I write further to receipt of your email last week regarding the proposed redevelopment of No.107 Felpham Way. In your email you refer to several issues which you considered required further thought.

Drg.No.HOP-002-P. Rev F

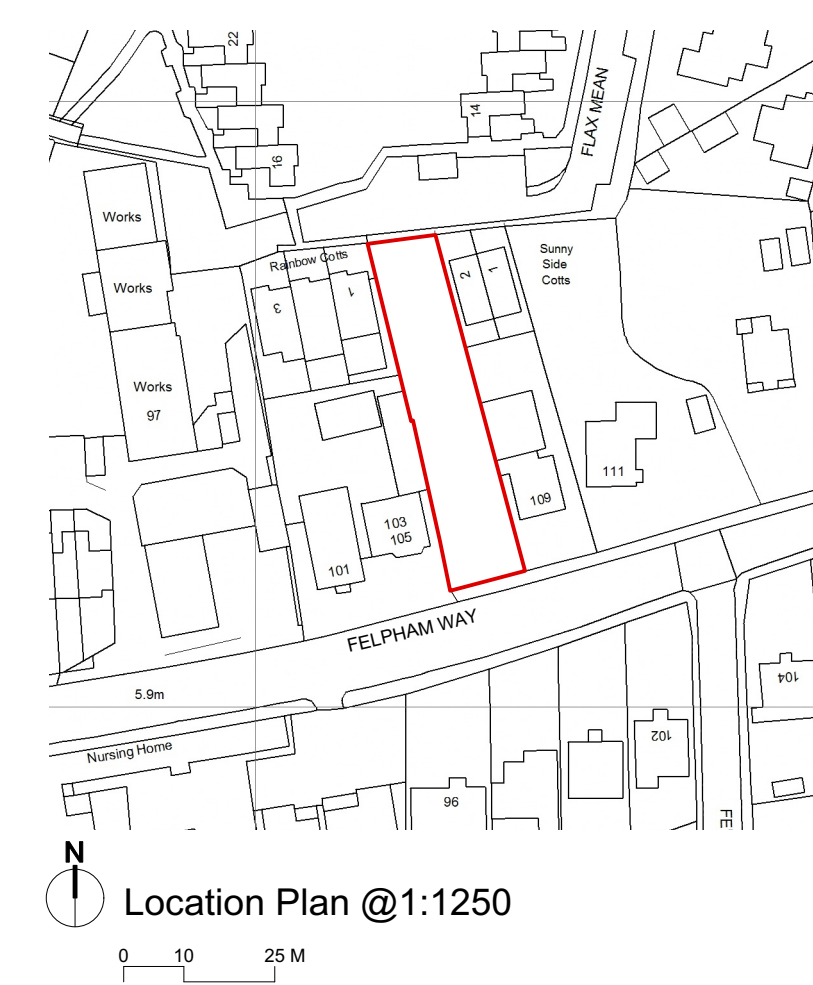
In your proposal you are opening proposed Commercial Unit to the west showing windows and door to 1m deep 'yard' facing to the entrance of 15A with no access? It would violate the privacy of the occupiers of that flat.

The proposed unit 1(ground floor would have a poor outlook from bedroom with a window facing to the wall within a distance 1m what is not acceptable.

Unit 3 (first floor) habitable room windows on the eastern elevation (within a distance of approximately 3m from the flank wall of No 109
With habitable window at the first floor level; not acceptable. The proposed bedroom shows low level roof light with a possibility of overlooking the private garden of 109.
In addition the proposed bedrooms (Unit 2) would have only rooflights with no outlook.

1. Commercial Unit The drawing has been revised to show a 2.2m high boundary fence which would run down the boundary between 105 and 107 Felpham Way. This would prevent any opportunity for overlooking of the door of 105A from the side door and windows within the commercial unit. Given that the replacement building would be constructed 1.0m from the common boundary at this point I would expect the door and yard area of 105A to receive more natural light than is currently the case.

2. Unit 1 The floor layout has been revised so that the two bedrooms are now on the east side of the flat. One bedroom has a window facing the garden; the second bedroom has a window with an outlook over the vehicular access running down the east side of the site. The light and outlook from the second bedroom would be similar to that of the bedroom window within the ground floor flat approved under FP/208/08/ which also looks out over this access.

3. Unit 2 The layout of this flat remains unchanged. However, I would like to clarify that the rooflights serving this flat would have a cill height set at approximately 1.1m above internal finished floor level which would allow future occupiers an outlook over the top of the adjacent single storey building to the west.

4. Unit 3 Planning permission was granted for FP/208/08/ for the provision of 4 flats at No.109A Felpham Way. One of the bedroom windows in the west facing first floor flat was separated by a

similar gap from the current application property. This relationship is not very different and has been considered to be acceptable by the LPA in the past. With regards to the potential overlooking of the rear of 109 Felpham Way I can advise you that the rear of No.109A has planning permission for use as a parking area (FP/208/08/) and is not a garden.

Ground Floor Plan - Proposed 1:100

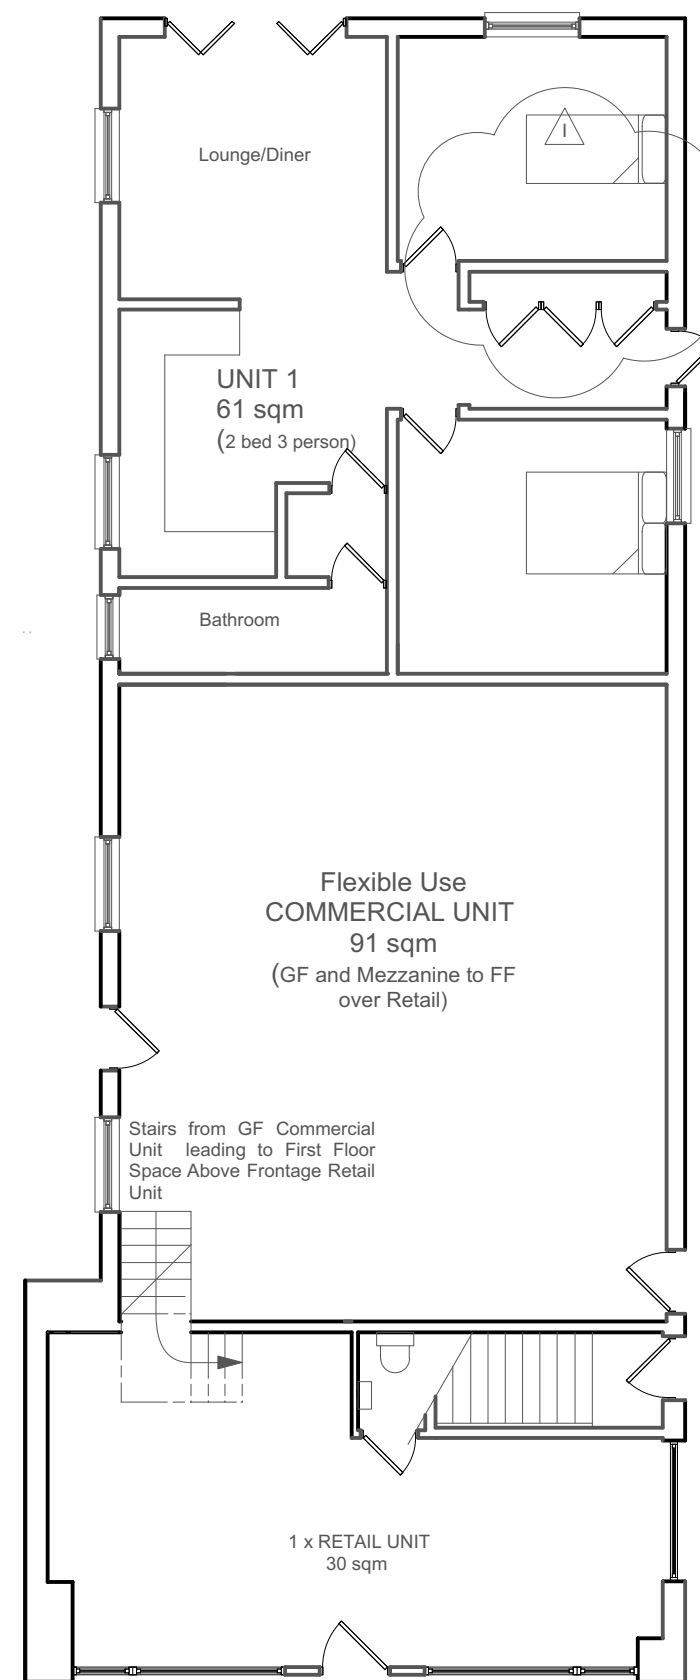
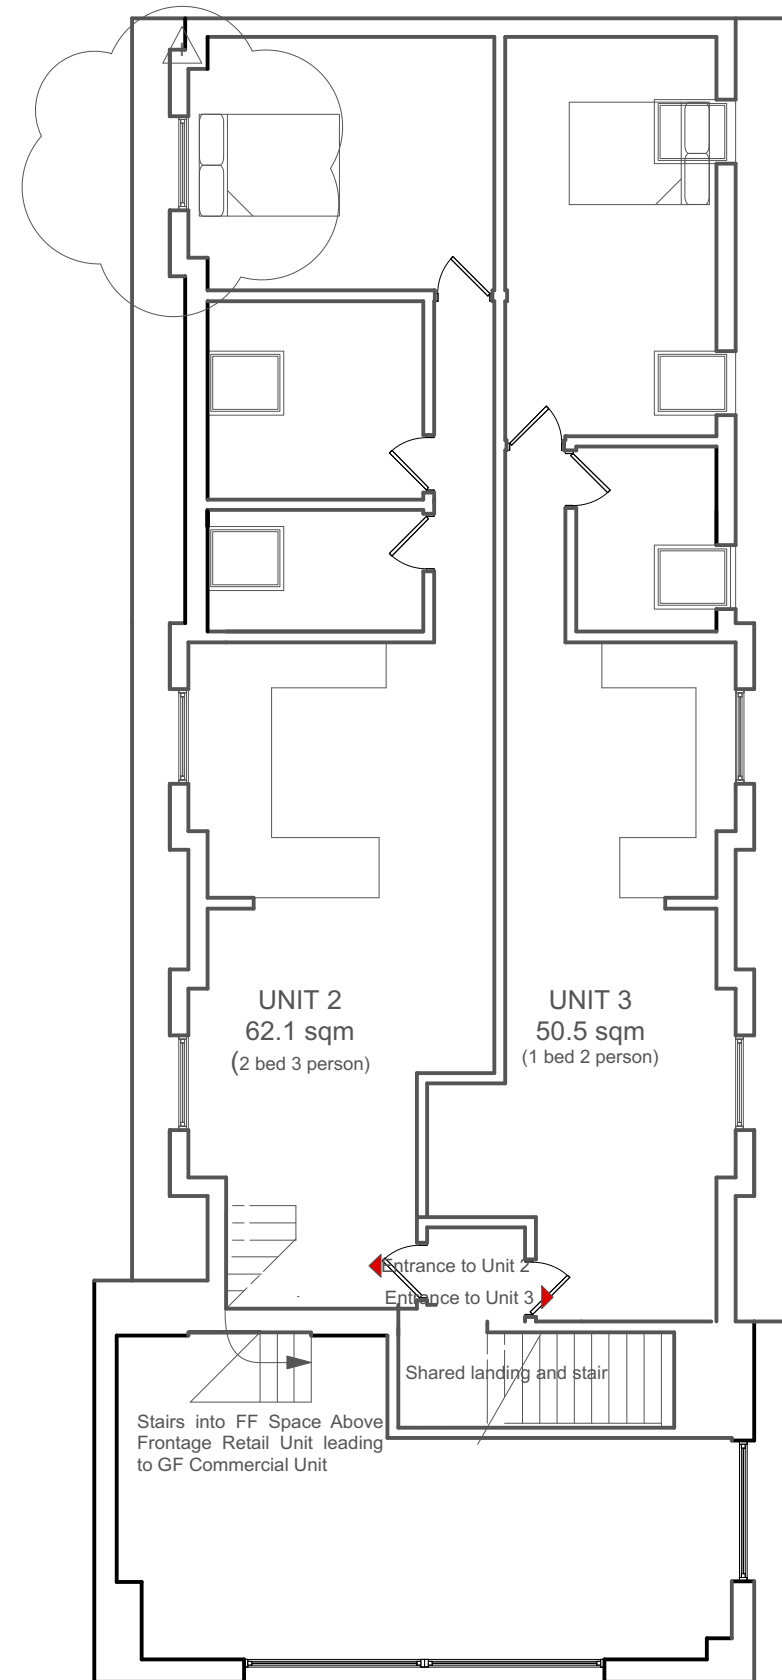
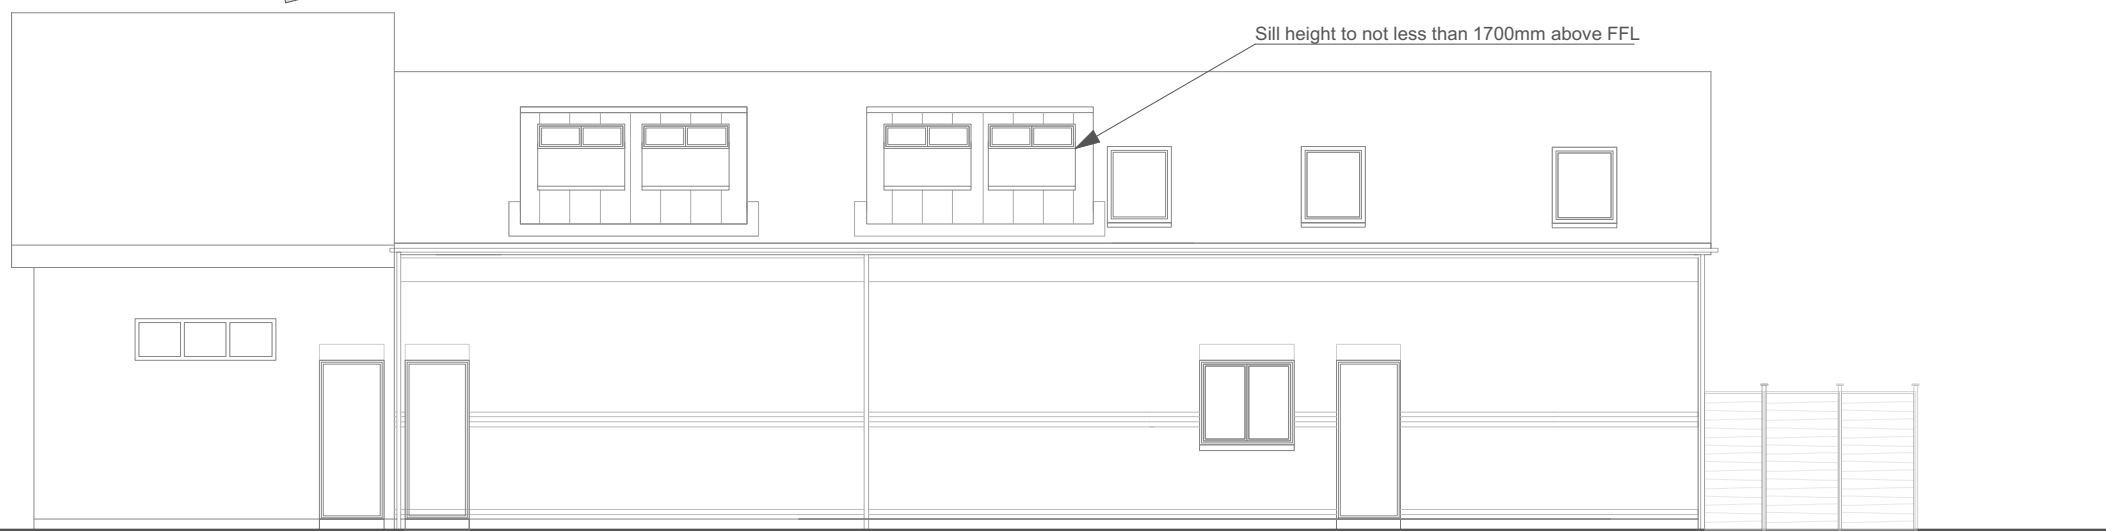
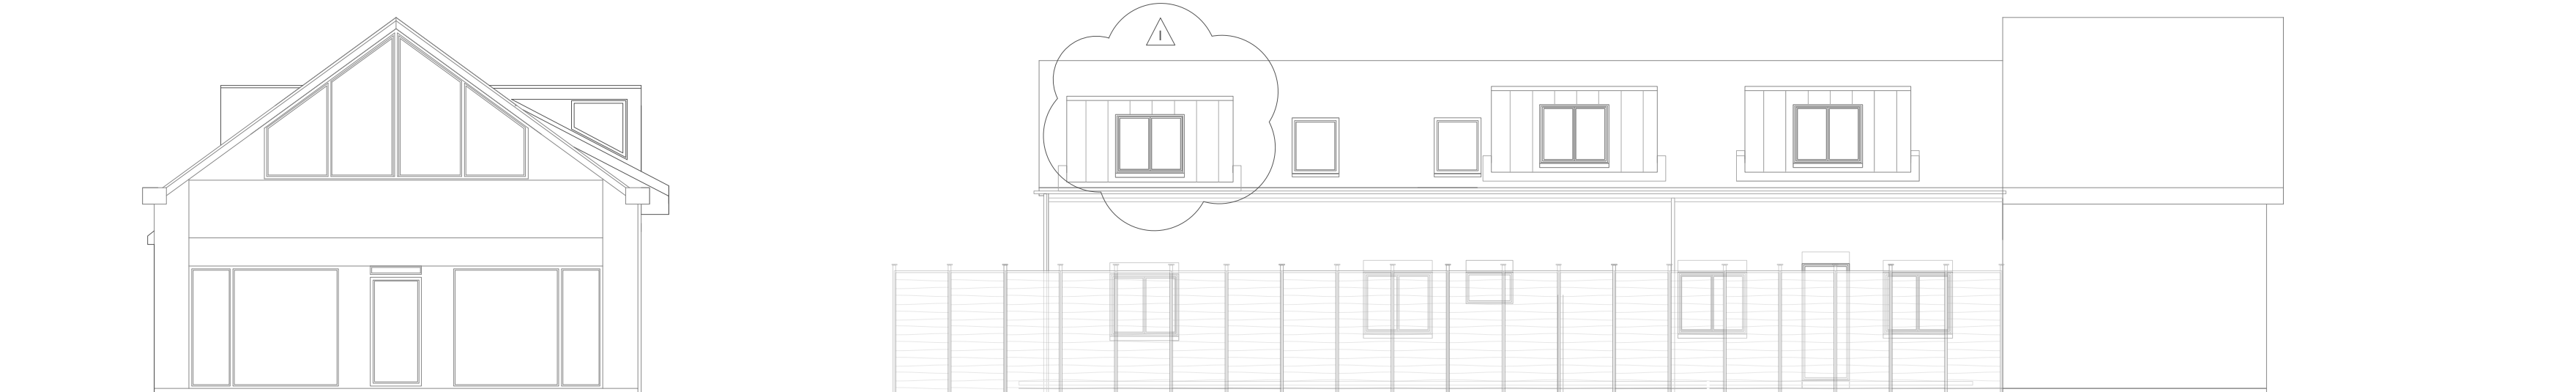
1. Unit 1 – this is annotated to say 2 bedroom, 3 person flat. You will see that one of the bedrooms has been reduced in size and the width of the hallway increased to include internal storage facilities.
2. Unit 2 is now shown with a dormer to the 'end' bedroom – with views across the adjacent commercial yard area.

1. Both east facing side dormers are now shown with clear glazing to their north and south “cheeks” (sides) together with high level windows within their front faces (or east elevations). Below the high level windows are proposed solid inset panels to provide a bit of relief and visual articulation. You will see that there is an annotation on the drawing stating “Sill height to not less than 1700mm above FFL”. I am hopeful that you will now agree that the dormer windows would not result in the overlooking of adjacent habitable room windows whilst at the same time offering future residents an acceptable outlook.

2. The proposed use of the forecourt has also been revised. This no longer shows the parking spaces as previously proposed and is annotated “Forecourt to be retained as existing”. You will also note a second annotation which states “Existing Disabled Access, Stepped Access and Bollards to be retained.”
